Our Case Number: ABP-316272-23

Re: Bus Connects Templeogue/Rathfarnham to City Centre Core Bus Corridor Scheme
Templeogue/Rathfarnham to City Centre

ABP case ref: 316272

BUSCONNECTS TEMPLEOGUE/RATHFARNHAM CORE BUS CORRIDOR SCHEME

Drawing File Name: BCIDC-ARP-GEO_GA-1012_XX_00-DR-CR-0003
Sheet Number: 03 of 42
Status: A
Rev: M01

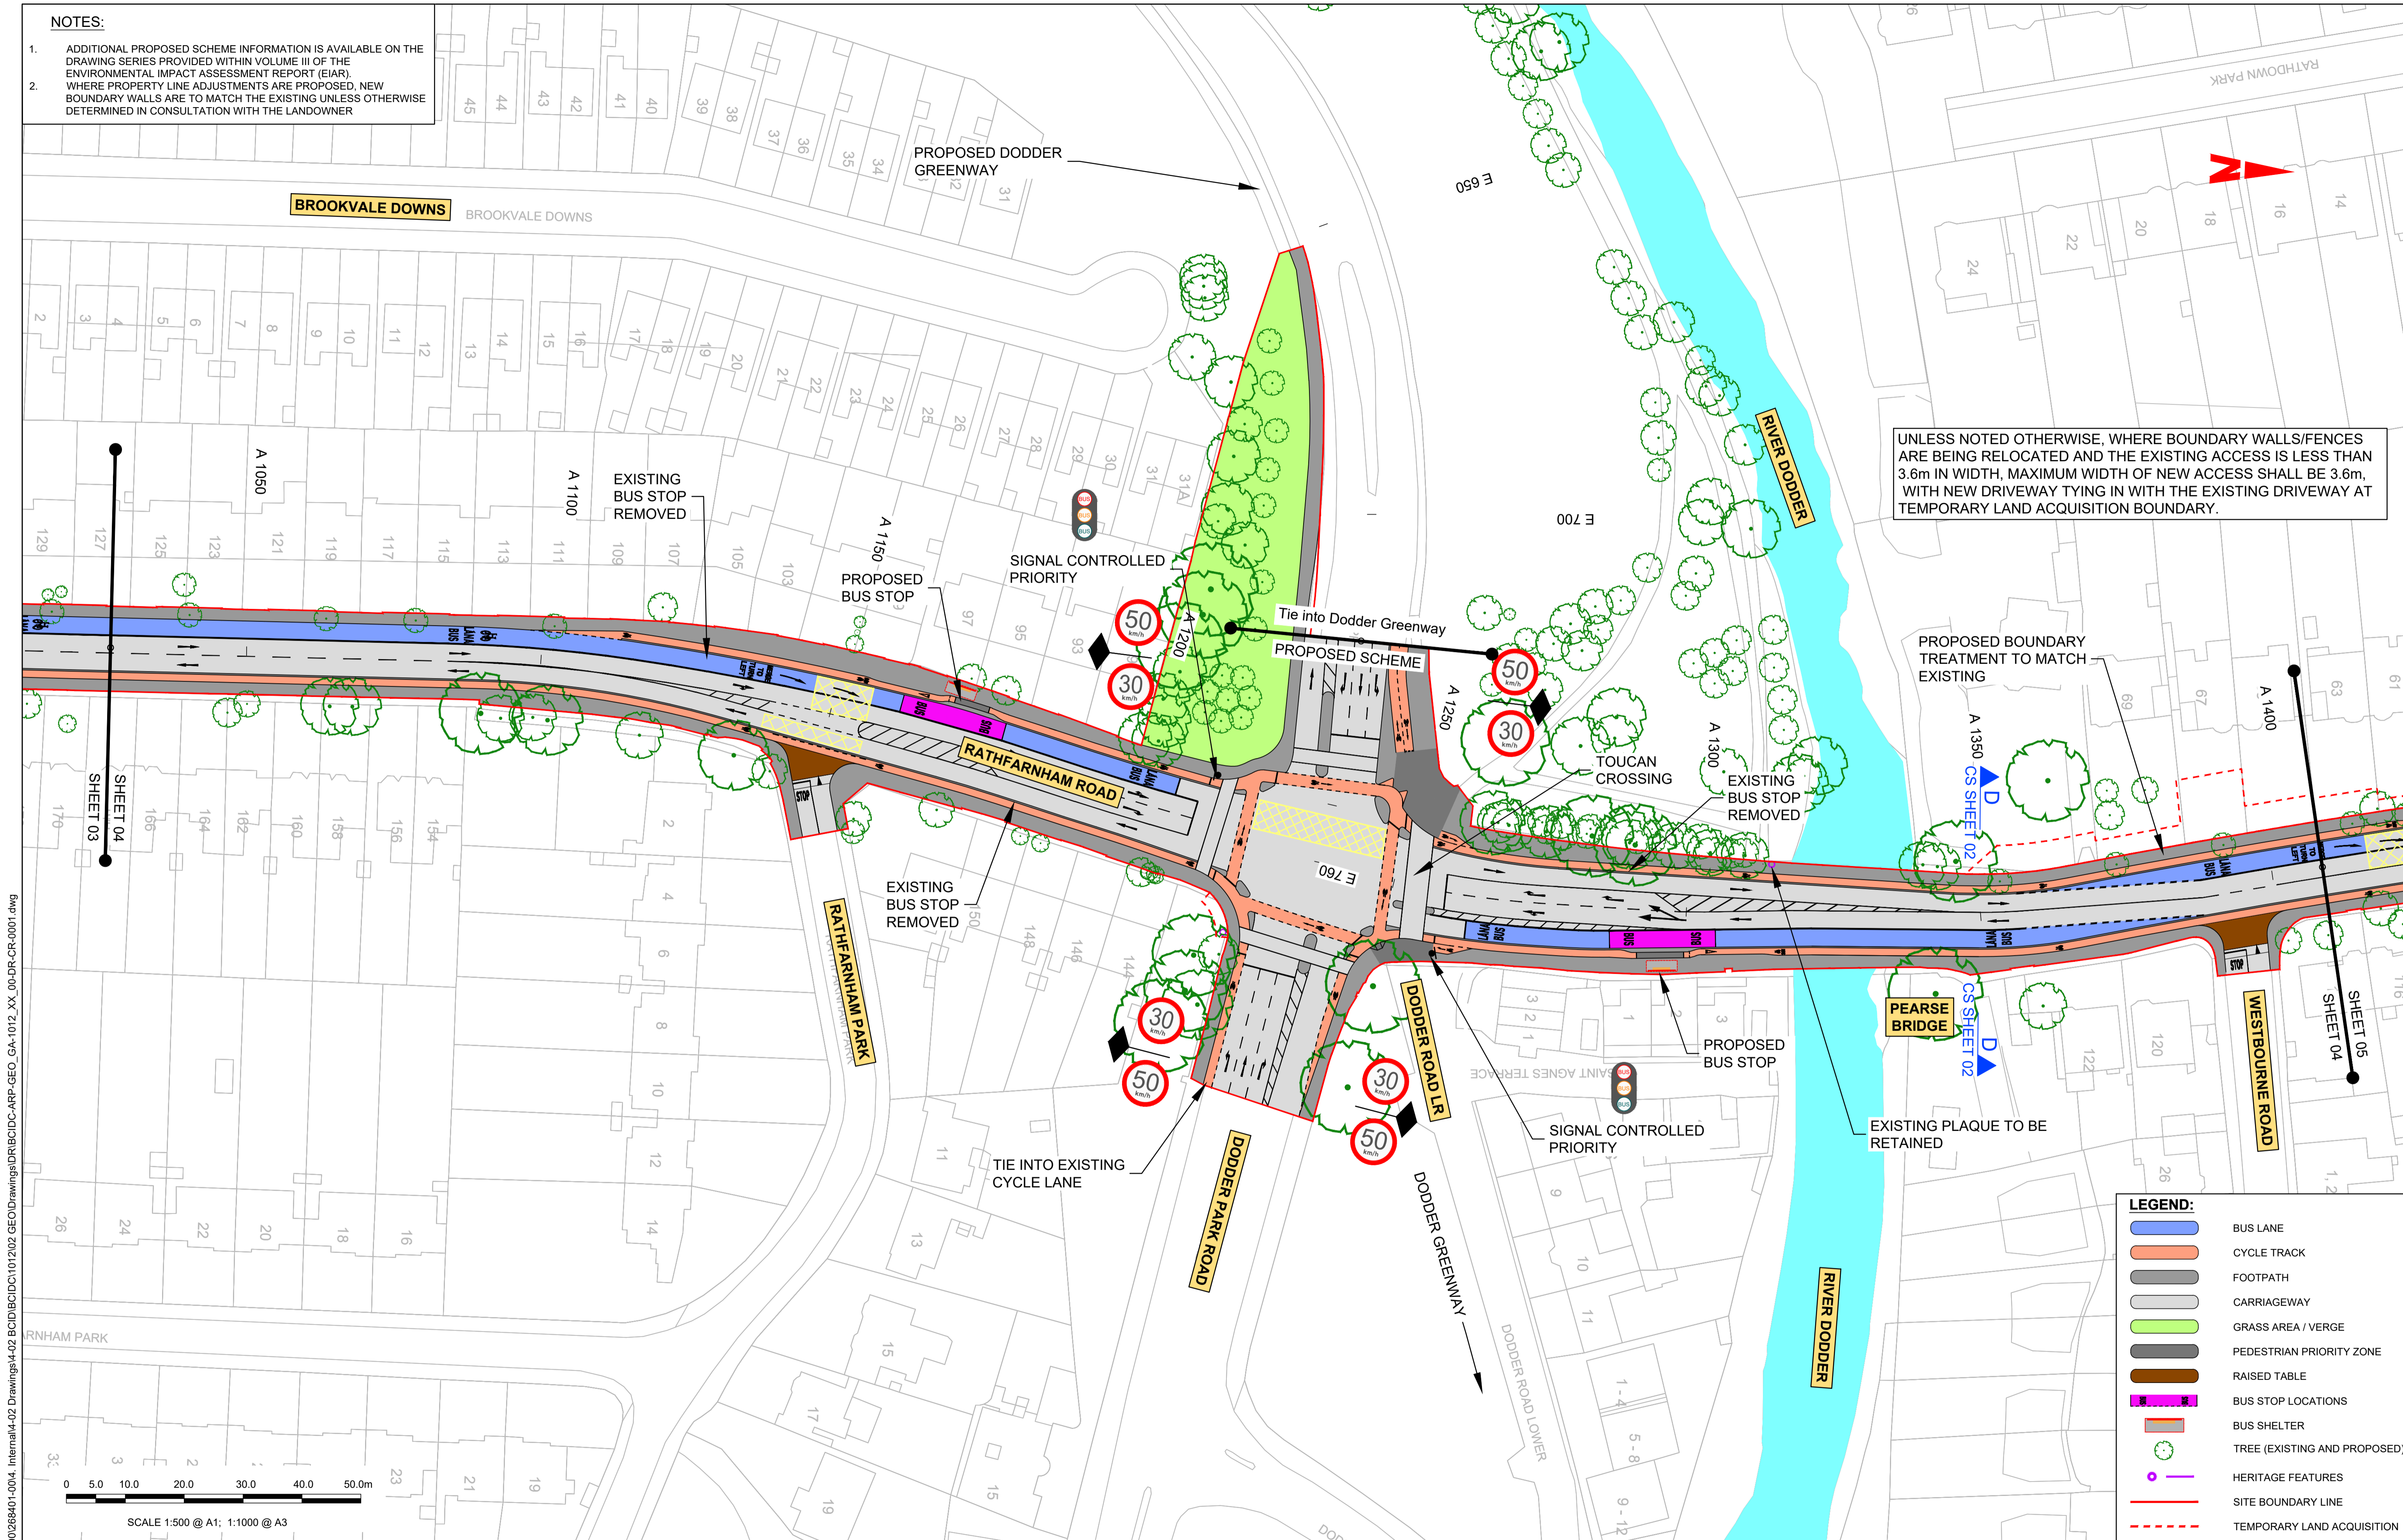
At the junction of Main Street and Rathfarnham Road (sheet 03/42), it is proposed that a bus stop be installed with a cycle track running in front of the shelter. As we previously mentioned, it is far safer to run the cycle track behind the bus shelter. As there is the available space to do so at this proposed stop, we would recommend that the bus shelter be brought forward and the cycle lane run behind to avoid potential conflicts between disembarking bus users and cyclists. The width of the island at this bus stop is also too narrow.

Programme Title: BUSCONNECTS DUBLIN			
CORE BUS CORRIDORS INFRASTRUCTURE WORKS			
Drawing Title: TEMPLEOGUE / RATHFARNHAM TO CITY CENTRE CORE BUS CORRIDOR SCHEME			
GENERAL ARRANGEMENT			
Drawing File Name: BCIDC-ARP-GEO_GA-1012_XX_00-DR-CR-0004	Sheet Number: 04 of 42	Status: A	Rev: M01

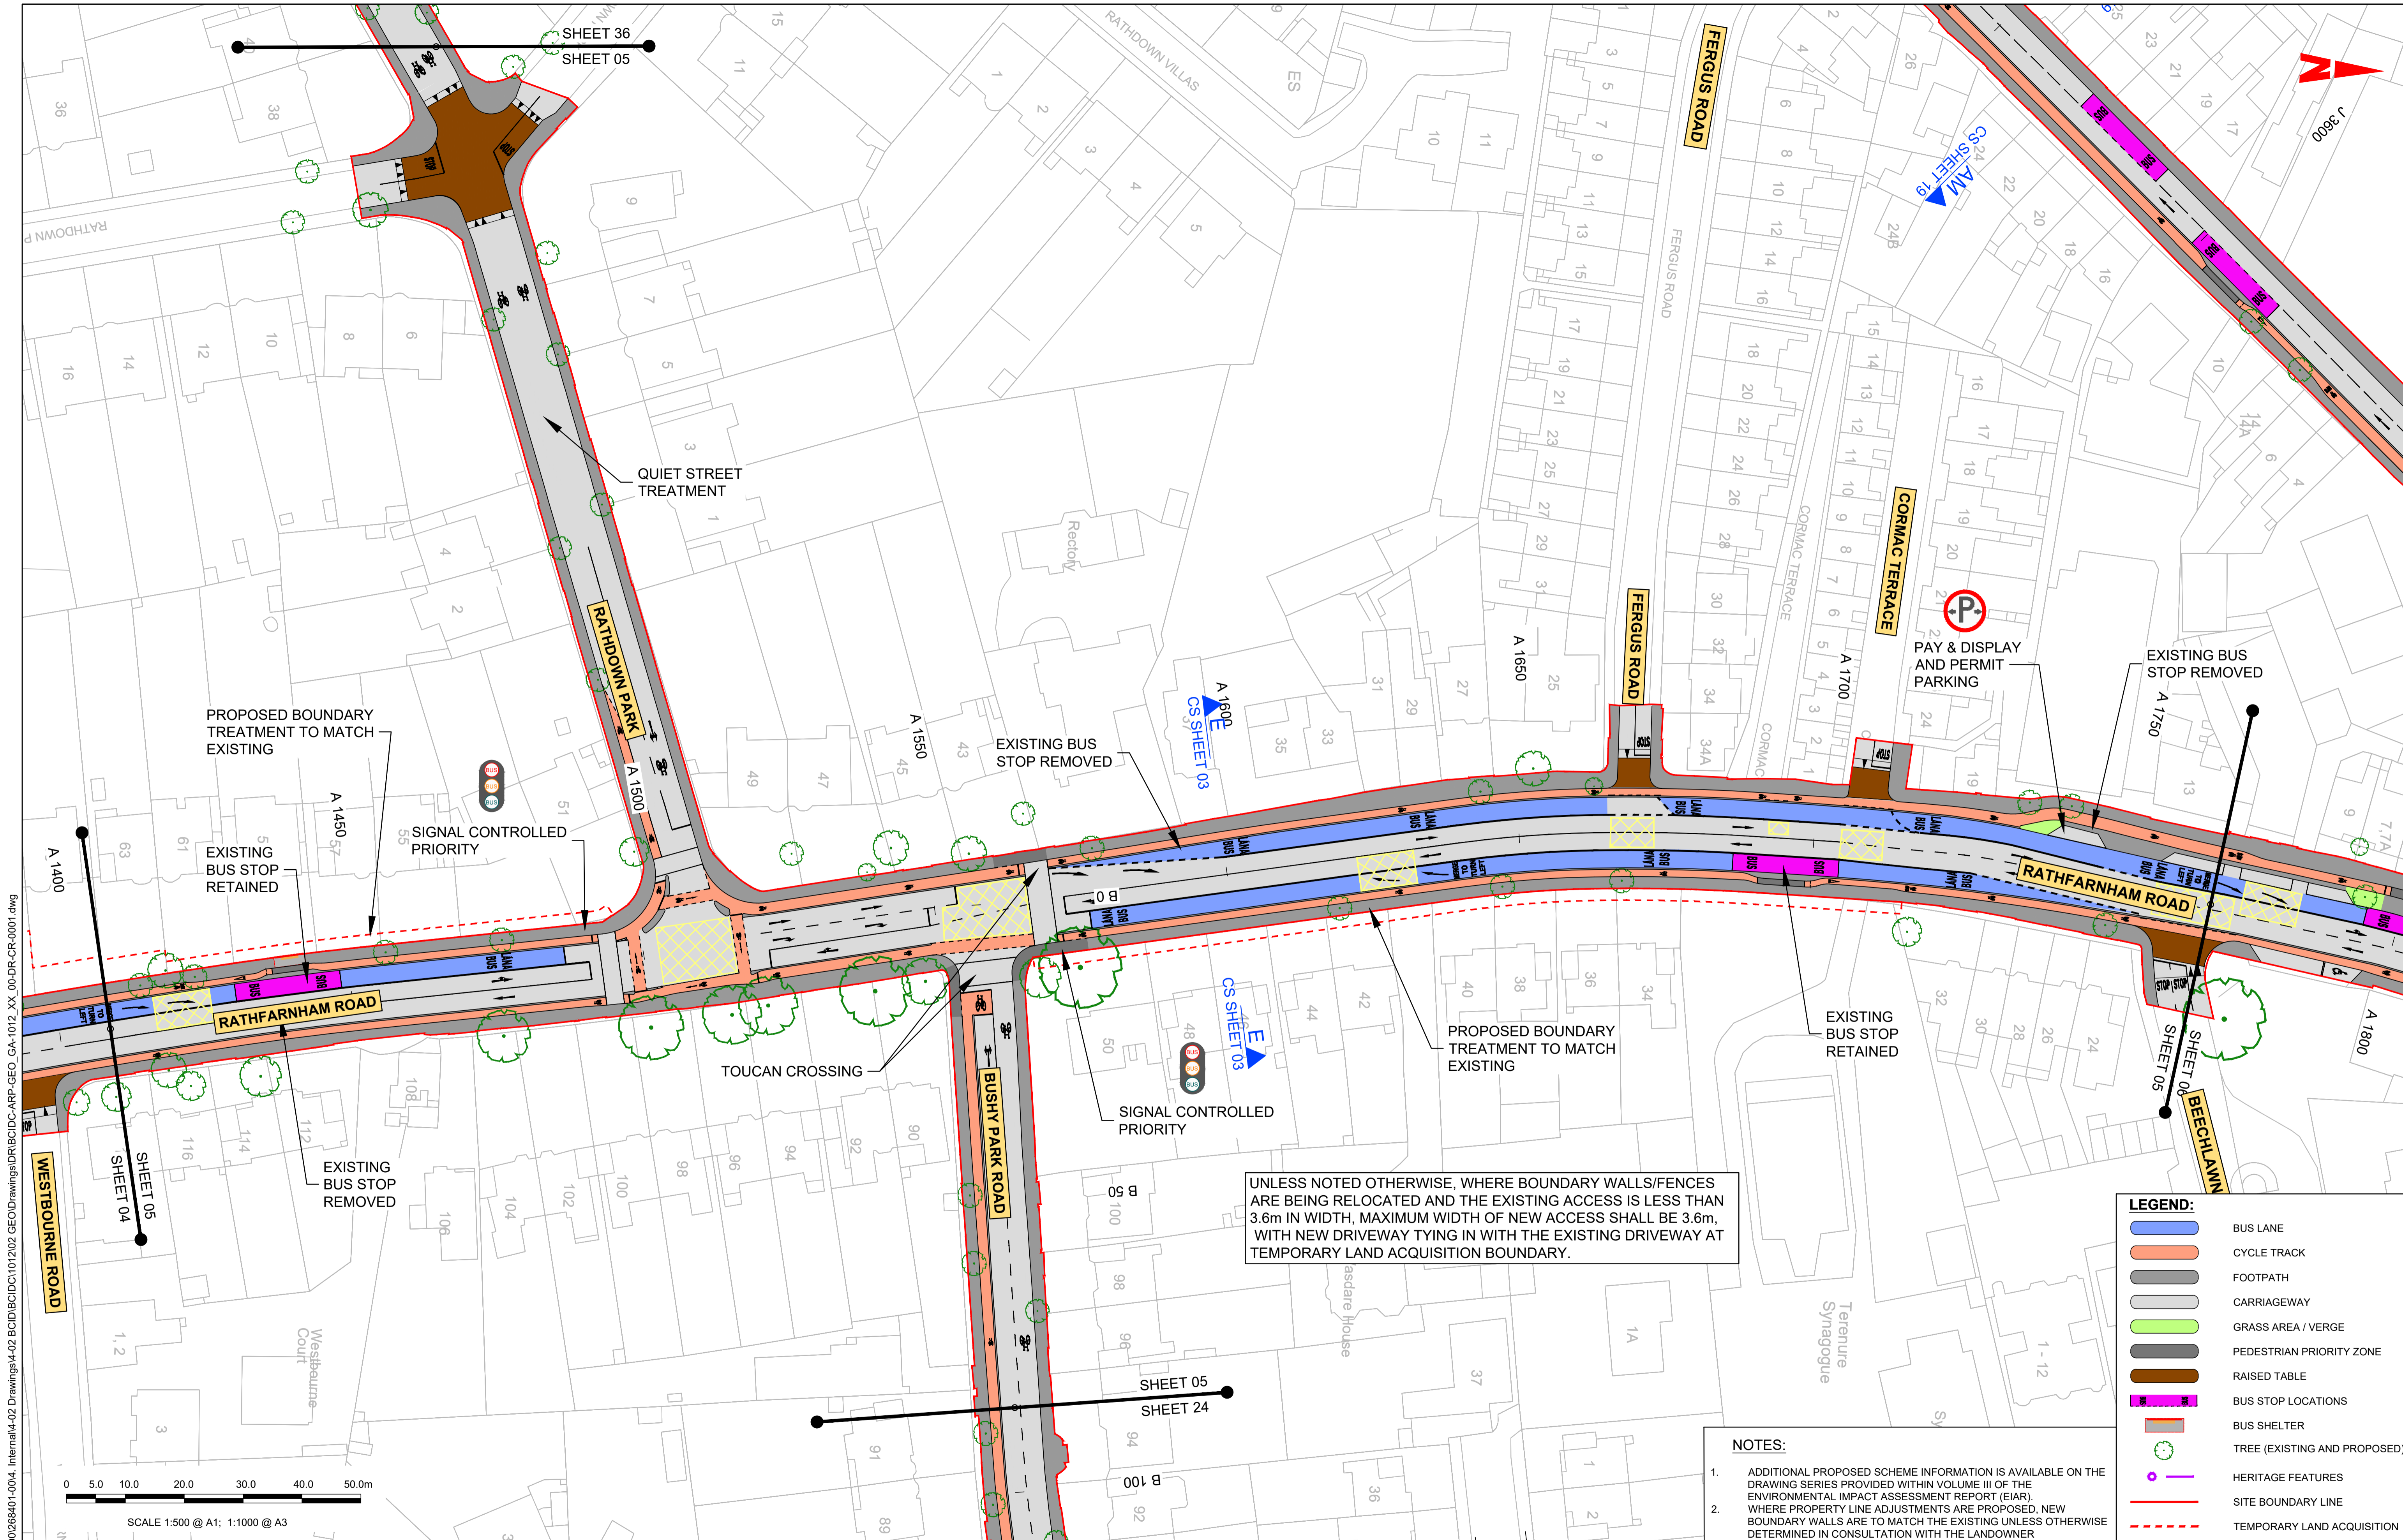
Given that there are three lanes of traffic on both sides of Dodder Park Road (sheet 04/23), we would request that priority signals be installed for cyclists at the junction. It is important to allow cyclists to fully clear the junction before left turning traffic arrives to make the turn. This could be mitigated by upgrading to a Dutch-style junction as mentioned above.

Additionally, there appears to be a shared space areas for pedestrians and cyclists. This would likely lead to conflict between faster moving cycle traffic should cyclists have the green light at the junction while creating a separation from cars who may have the filter lane turn left. We would recommend creating clear segregation between the cycle tracks

and pedestrian footpaths to reduce potential conflicts between both cyclists and pedestrians & cyclists and vehicles at the junction.
